RESPONSE TO H23-0313-25: Amendment 2 - Updated drainage and block plans, together with revised access and visibility plans, have been submitted. Updated Biodiversity Net Gain (BNG) information has also been provided, including the biodiversity metric, baseline habitat plan and post-development habitat plan at Land At Peartree Hill Road, Whaplode Drove.

Lincolnshire Wildlife Trust wishes to maintain a **holding objection** on this application until the following concerns have been addressed.

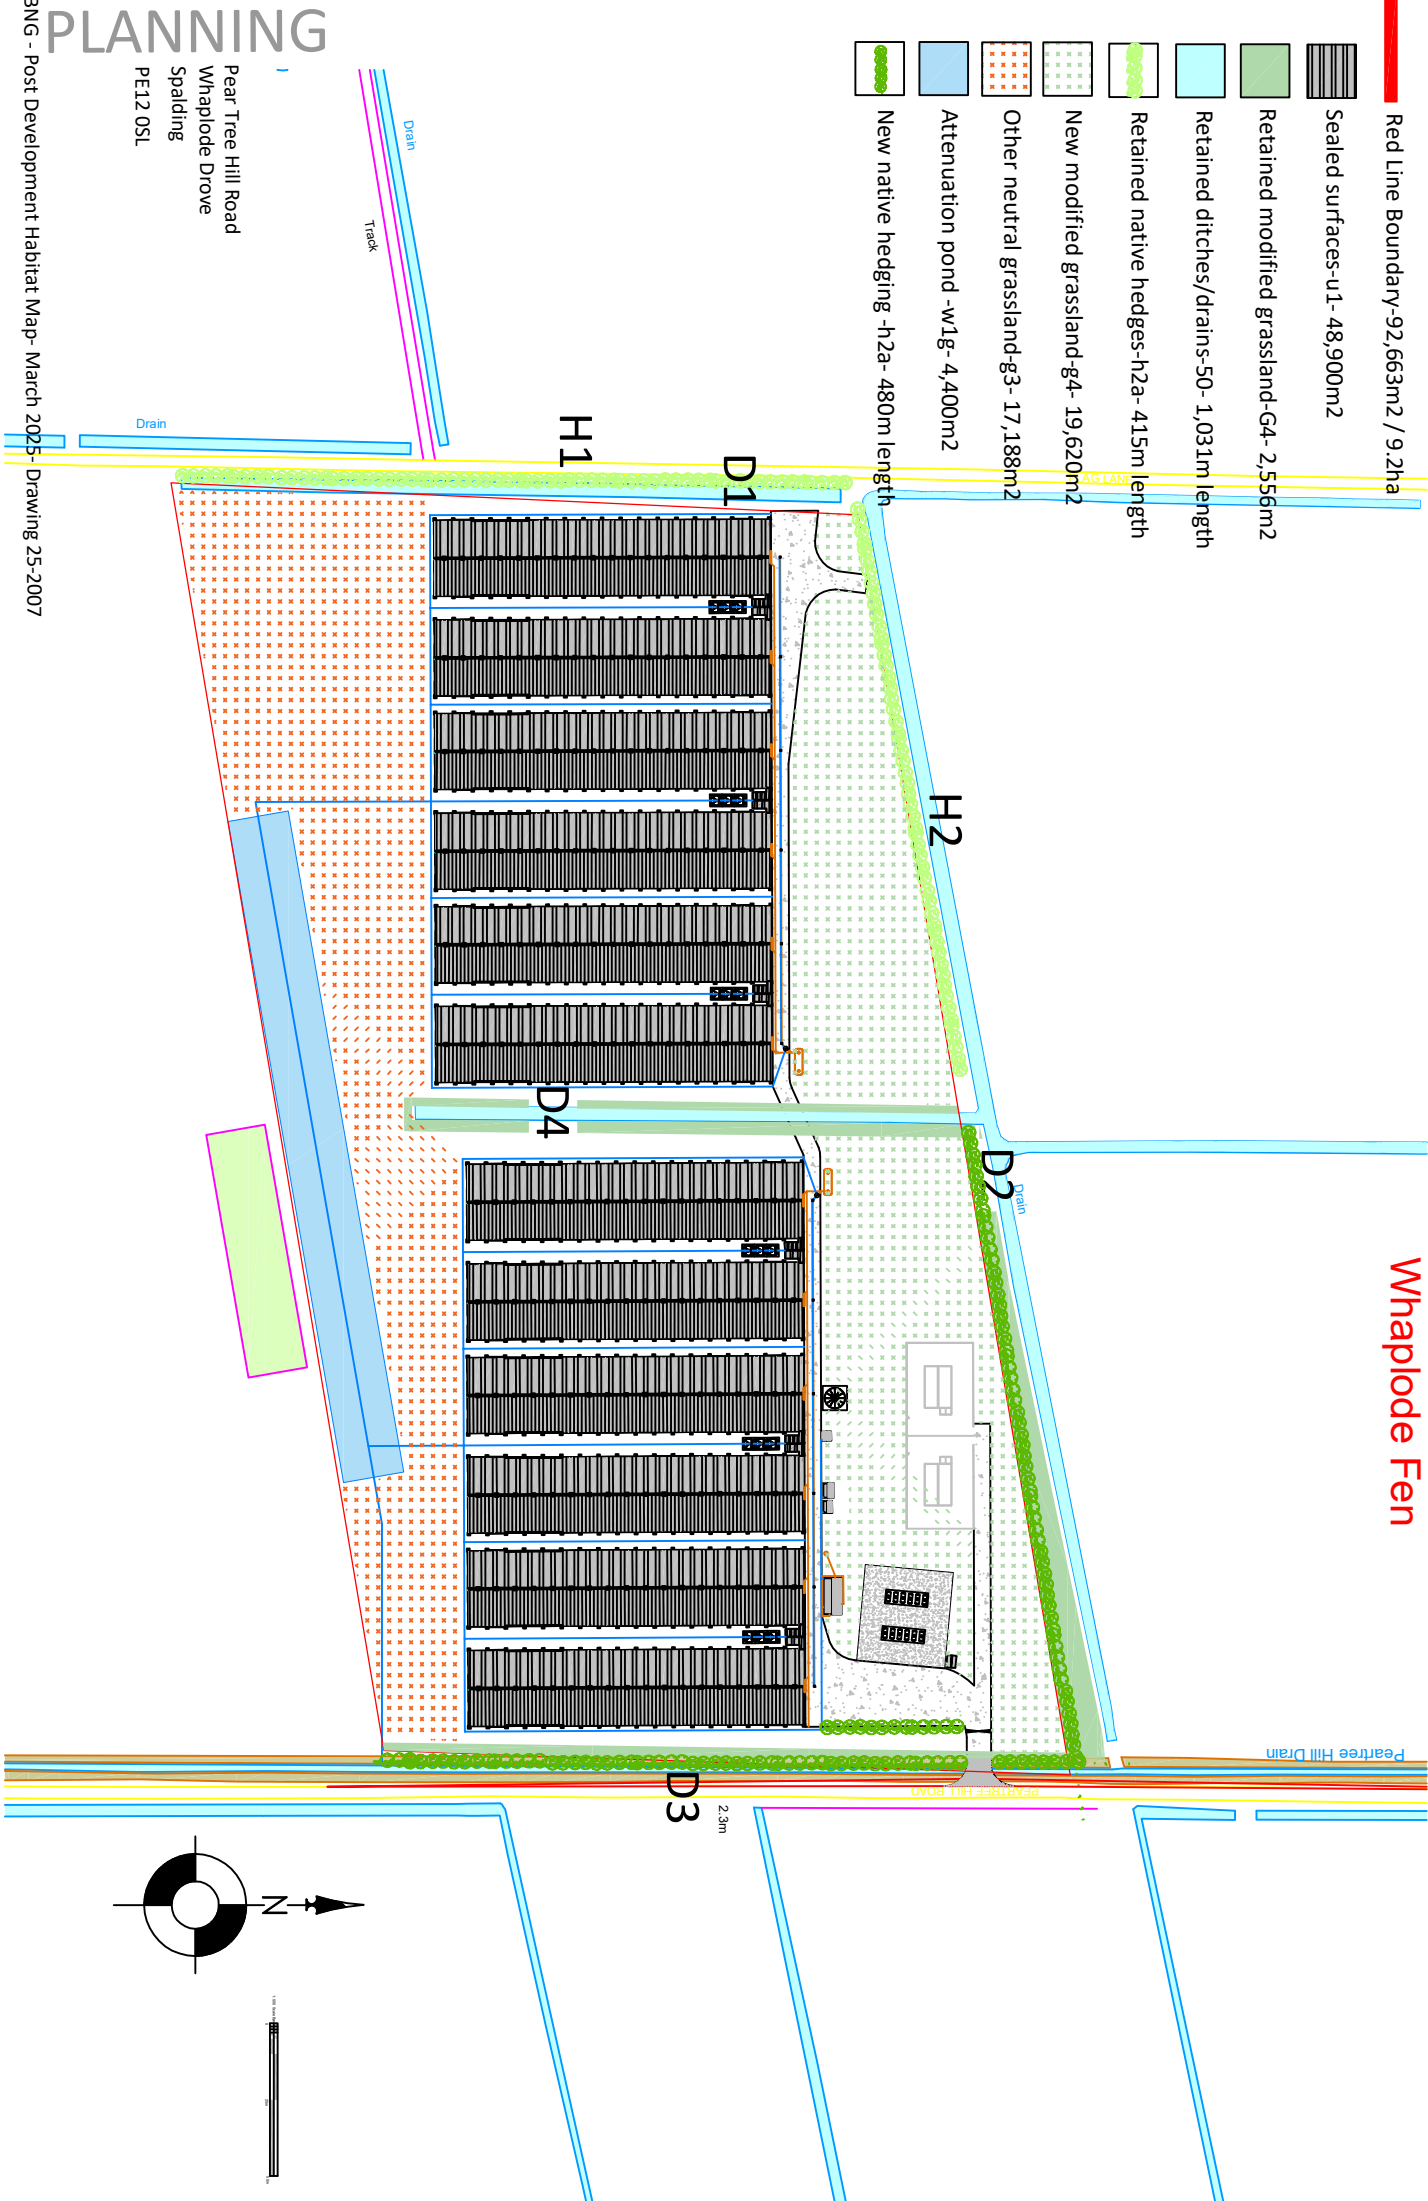
As identified by Senior Ecologist Chris De-Ruyck, there are several issues with the habitats proposed in the Biodiversity Net Gain (BNG) metric. Although the updated metric has removed the creation of good condition other neutral grassland, it still lists the creation of good condition modified grassland. This is an unrealistic condition due to the impacts of deposition of ammonia from the poultry sheds, as described in the response from Chris. Additionally, it lists enhancement of the onsite ditch to good condition, which would require it to pass all eight criteria, including achieving good water quality with no signs of pollution. The metric calculation should be adjusted, with provisions made to secure offsite biodiversity units to ensure a 10% gain is reached.
